REQUEST

Current Zoning: N1-A (neighborhood 1-A)
Proposed Zoning: N2-A(CD) (neighborhood 2-A, conditional)

Approximately 3.52 acres located along the north side Johnston Oehler Road and south of Barrow Road.

The petition proposes to develop a residential community to allow up to 45 multi-family attached dwelling units.

RZ-1.0

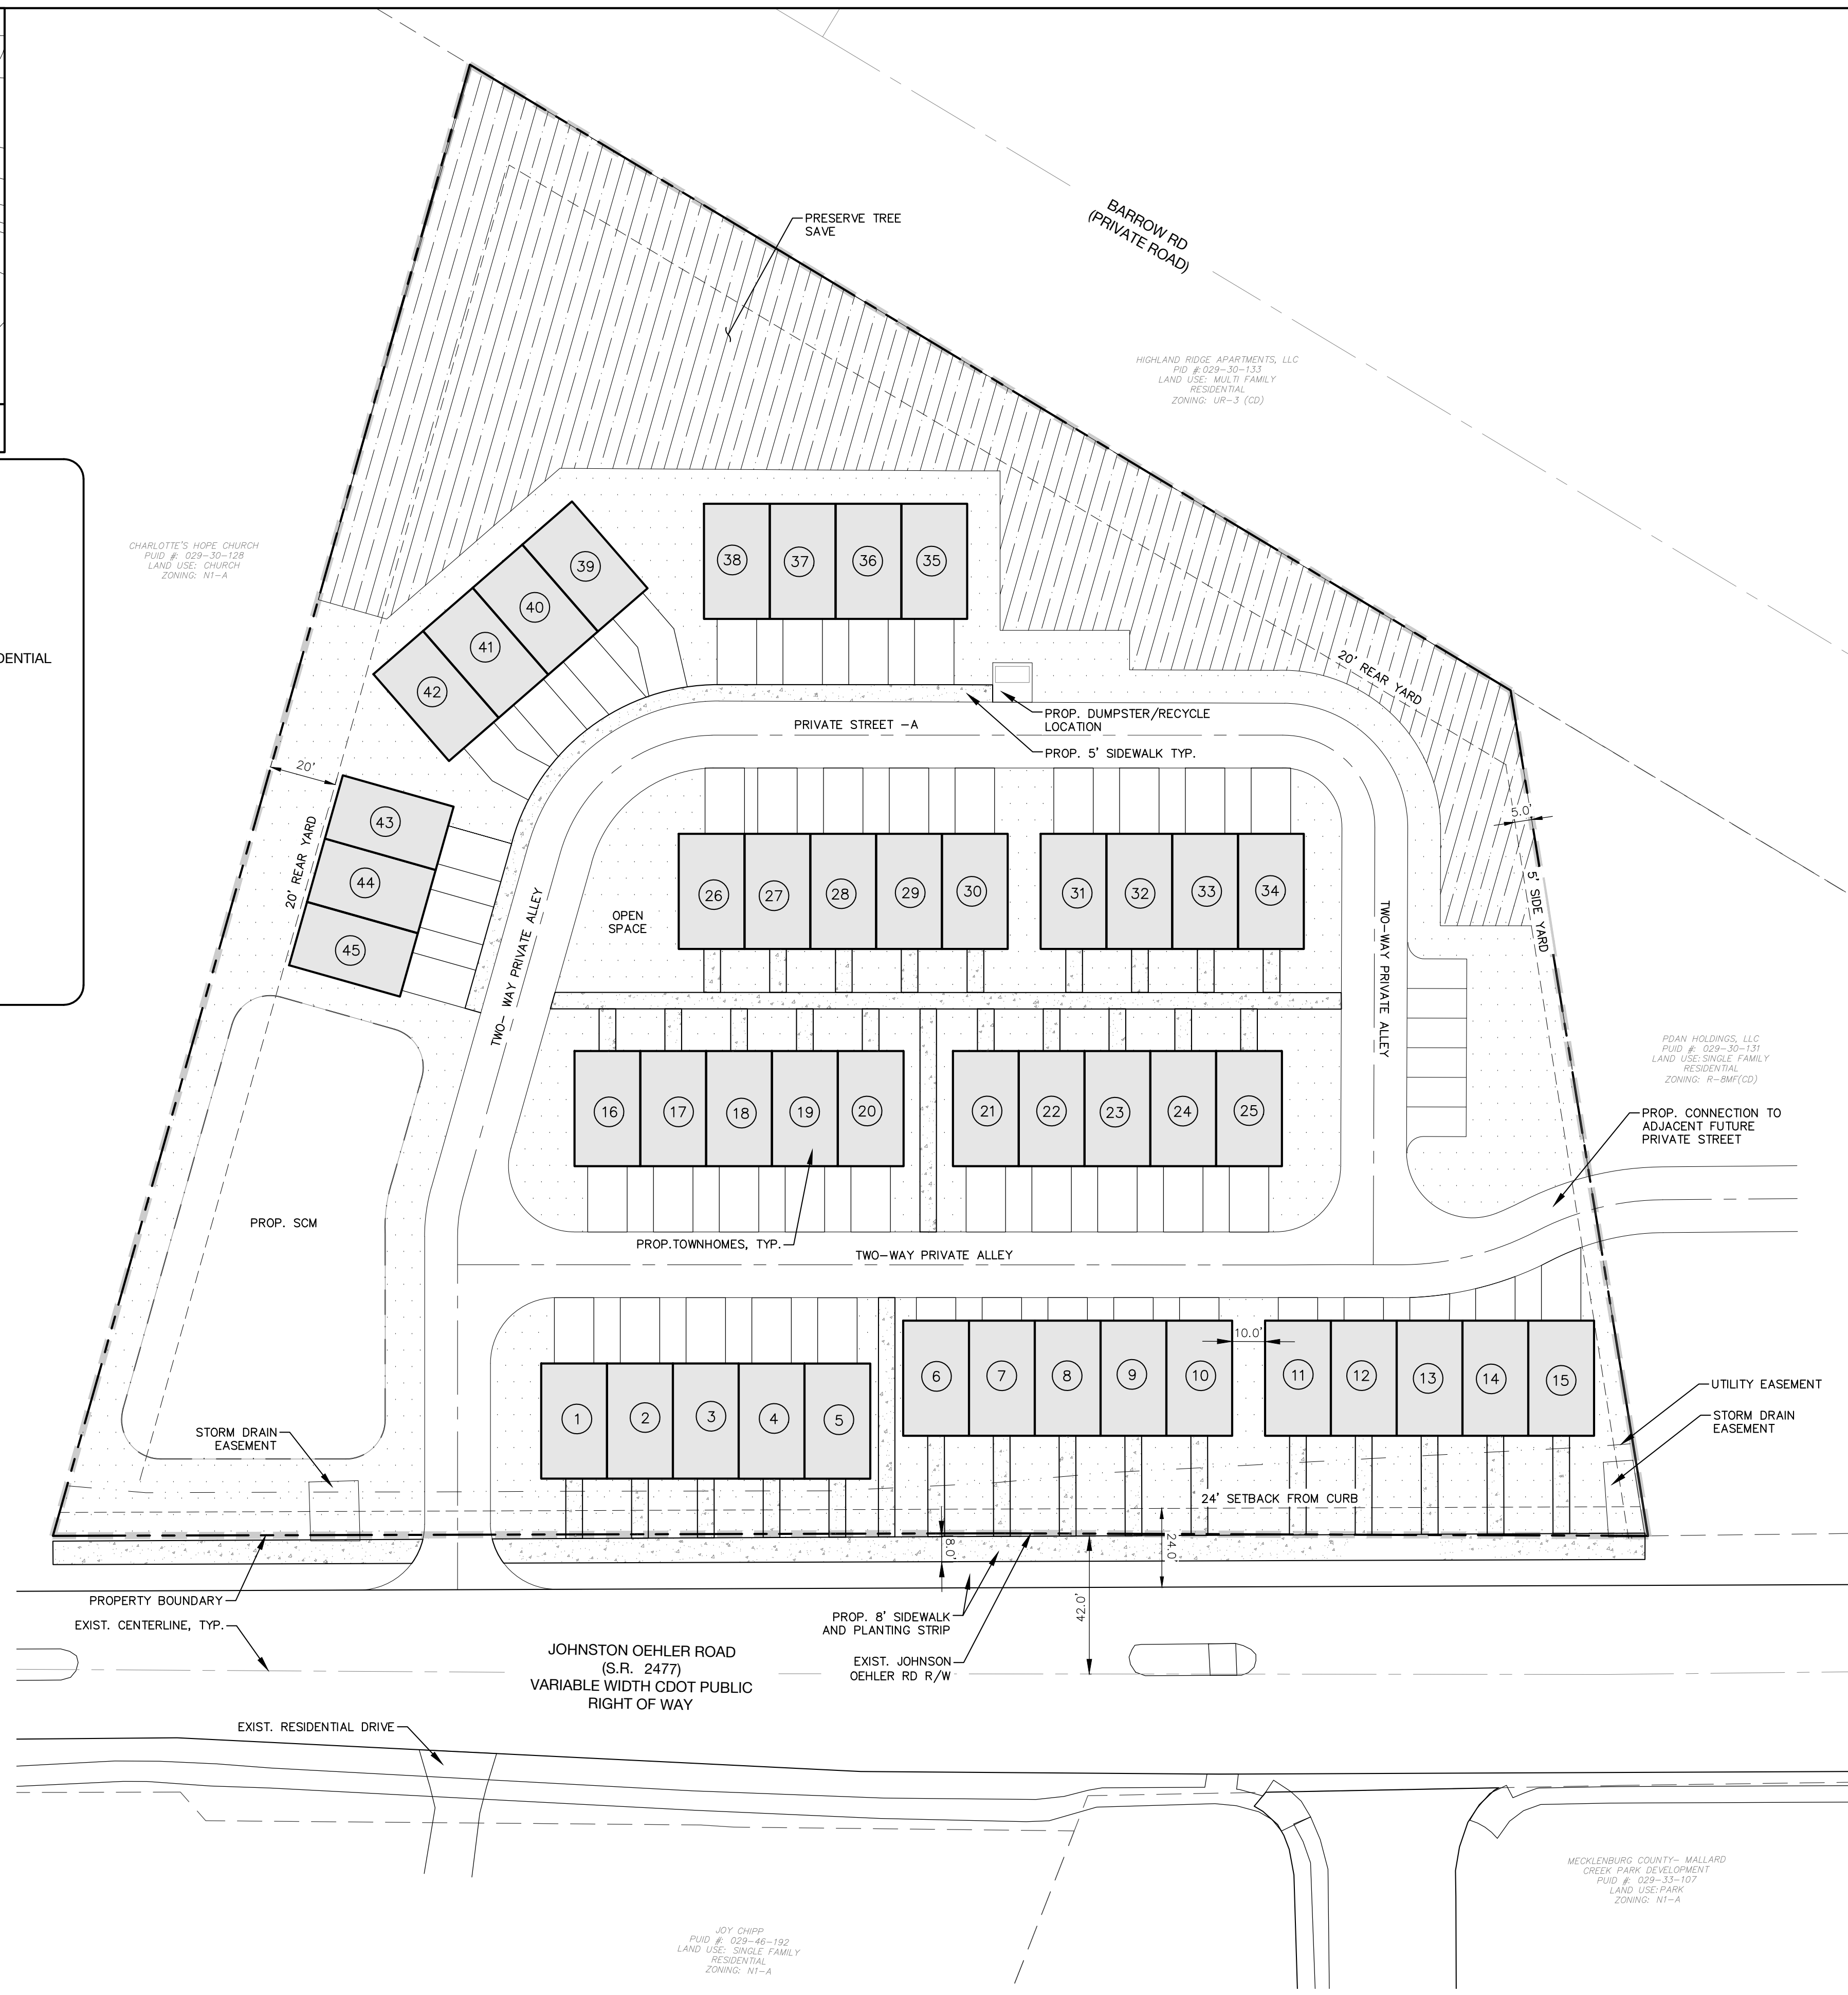
1. Site access is to line up with the residential driveway on the southern side of the roadway. Addressed

2. Revise site plan and conditional note(s) to commit to installing a signalized pedestrian crossing at the existing pedestrian crossing location that would allow for connection to Mallard Creek High School. Addressed
3. Remove conditional note referencing reverse angle parking. Addressed

4. Minimum tree save width for protected area is 30-feet. Addressed
5. Tree survey required. Addressed
